RE: **Undi Commerce Park
Technical Review #2**

The responses below correlate to the numbered review comments on your letter dated July 18, 2023.

Harold Christensen
Architect
Lance Mueller & Associates

PJLA JOB NO.:
DRAWN BY: PJ

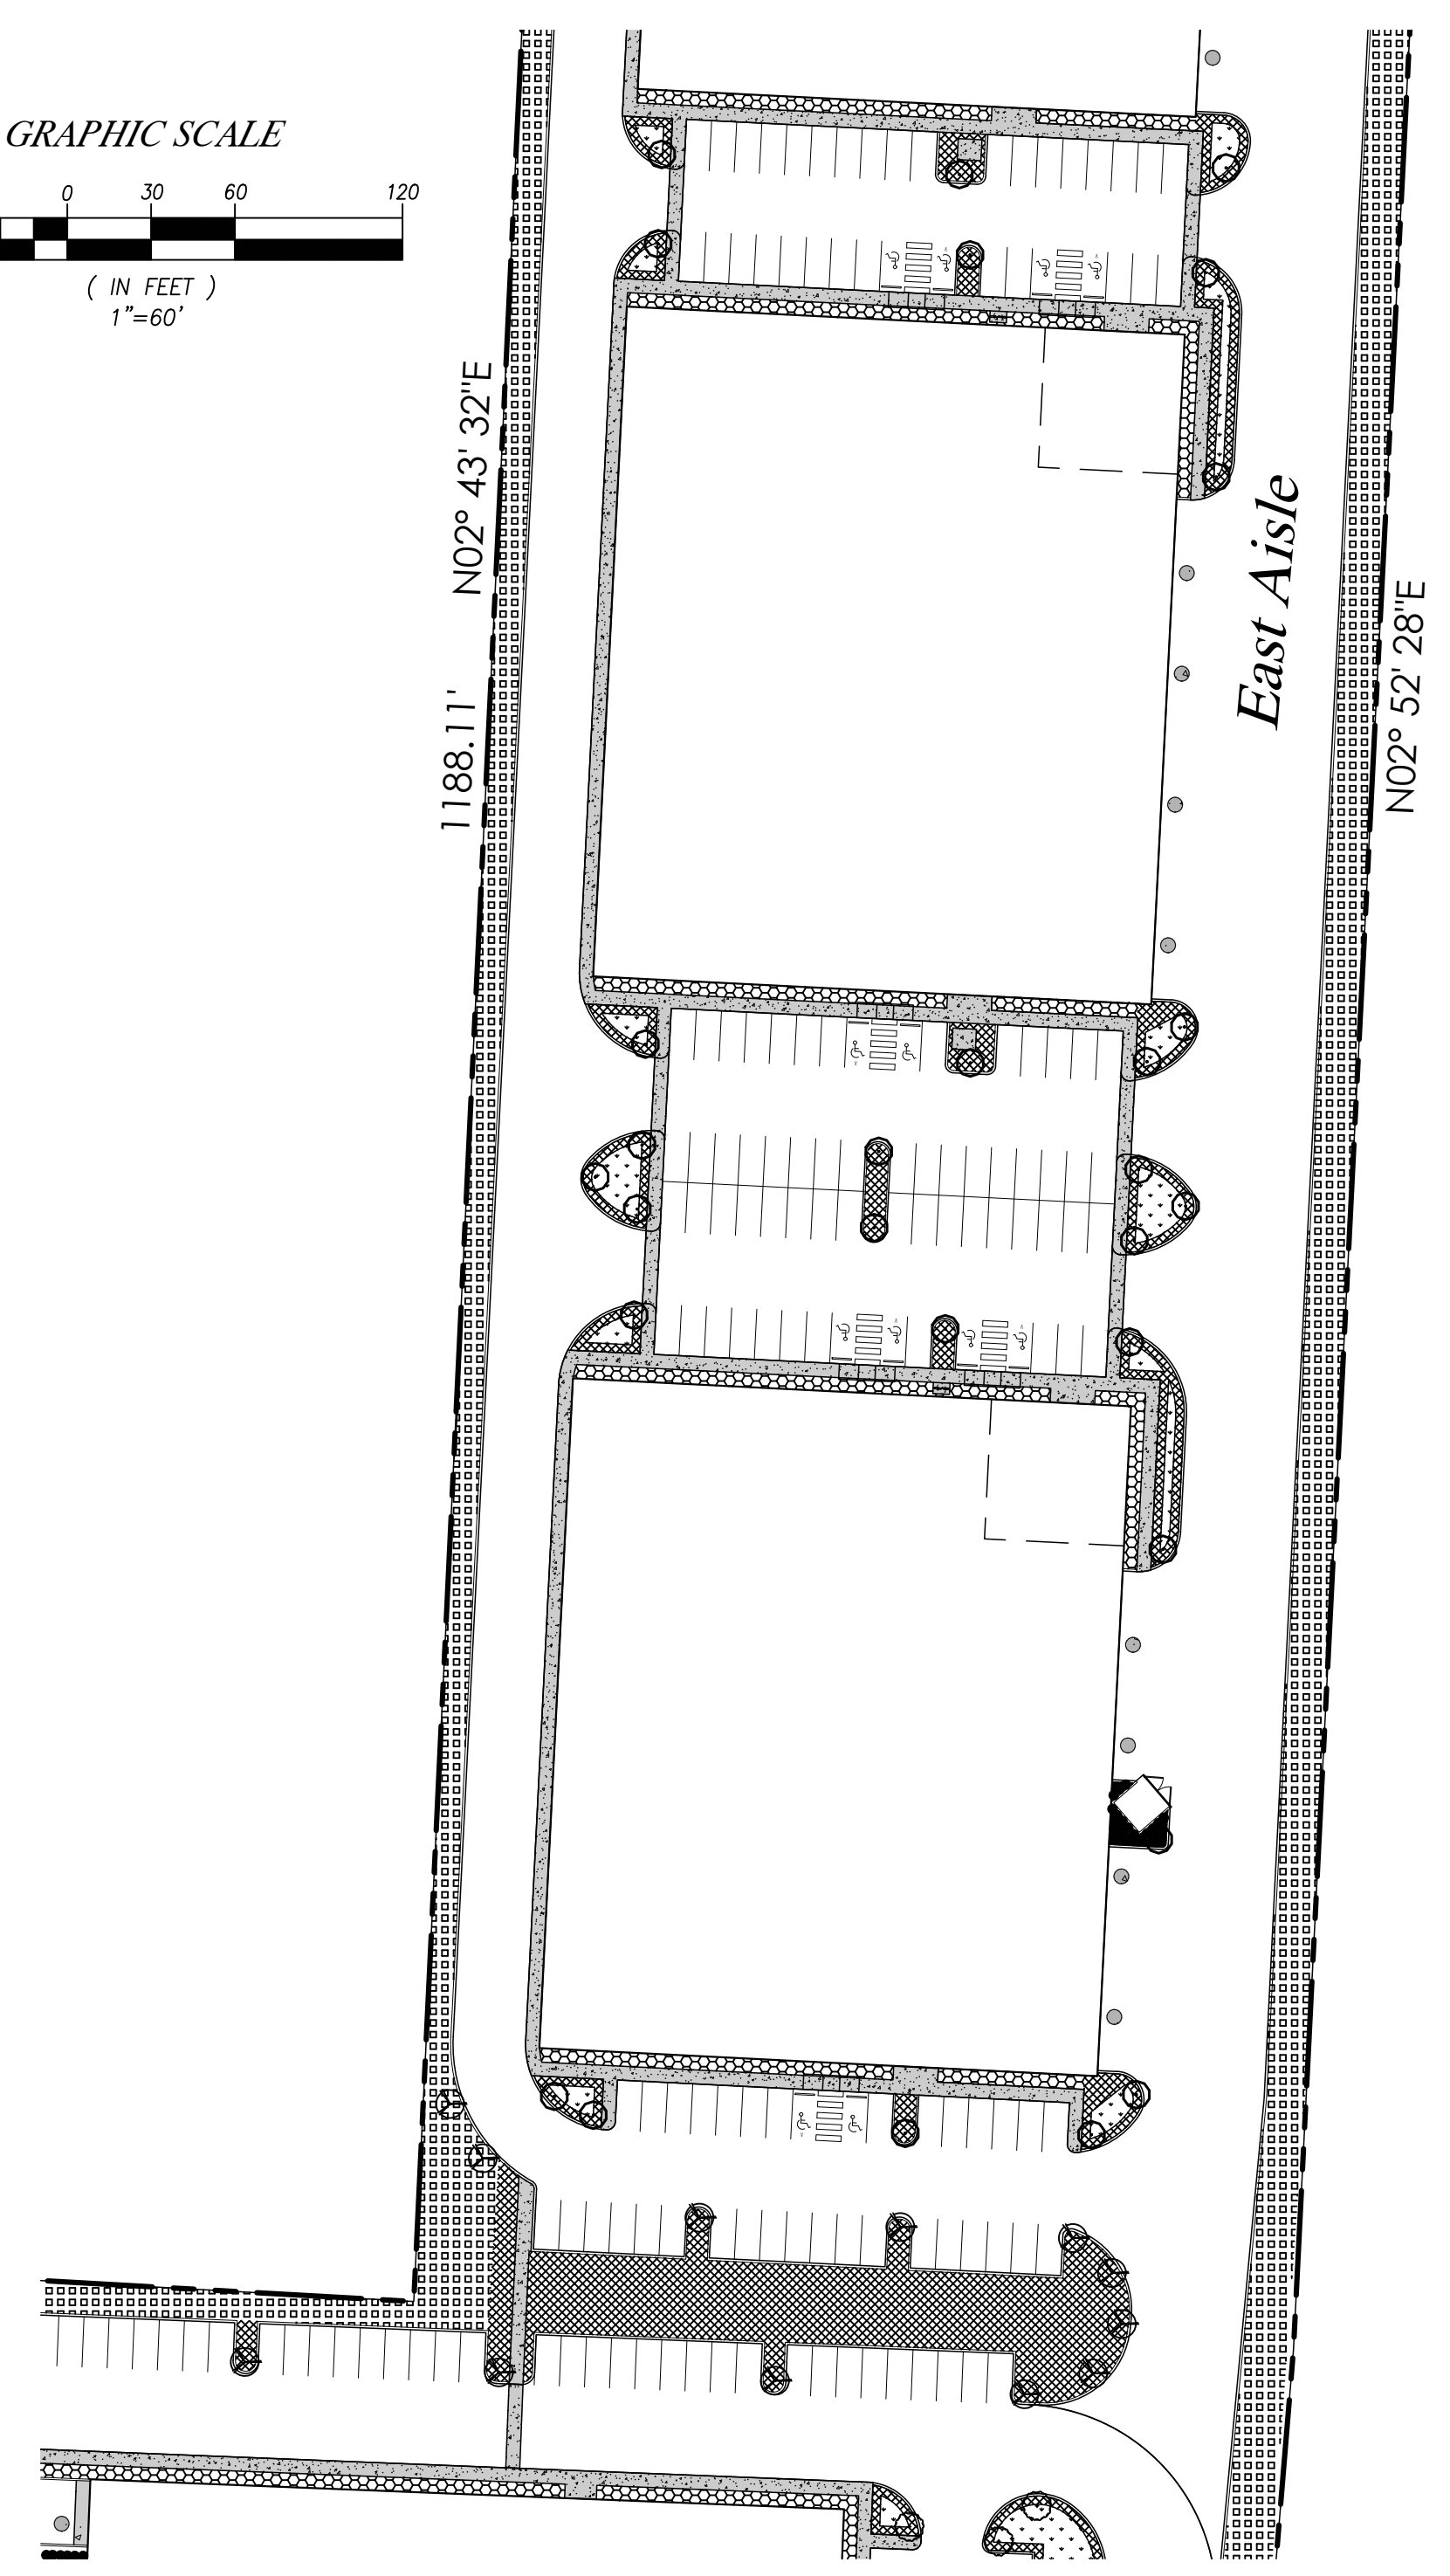
- 1a. Cover sheet showing entire site has been added to the plan set. See sheet A0.0.
- 1b. A pedestrian connection to 152nd Street NE has been added to the architectural, civil and landscape plans. See A0.0, and A1.1.
2. See attached copy of renewed NWP.
3. The access to Scott's site has been eliminated from the scope.
4. Preliminary landscaping plans depicting the elements outlined in your letter has been added to the set. See sheets L-1 through L-6.
5. Acknowledged.
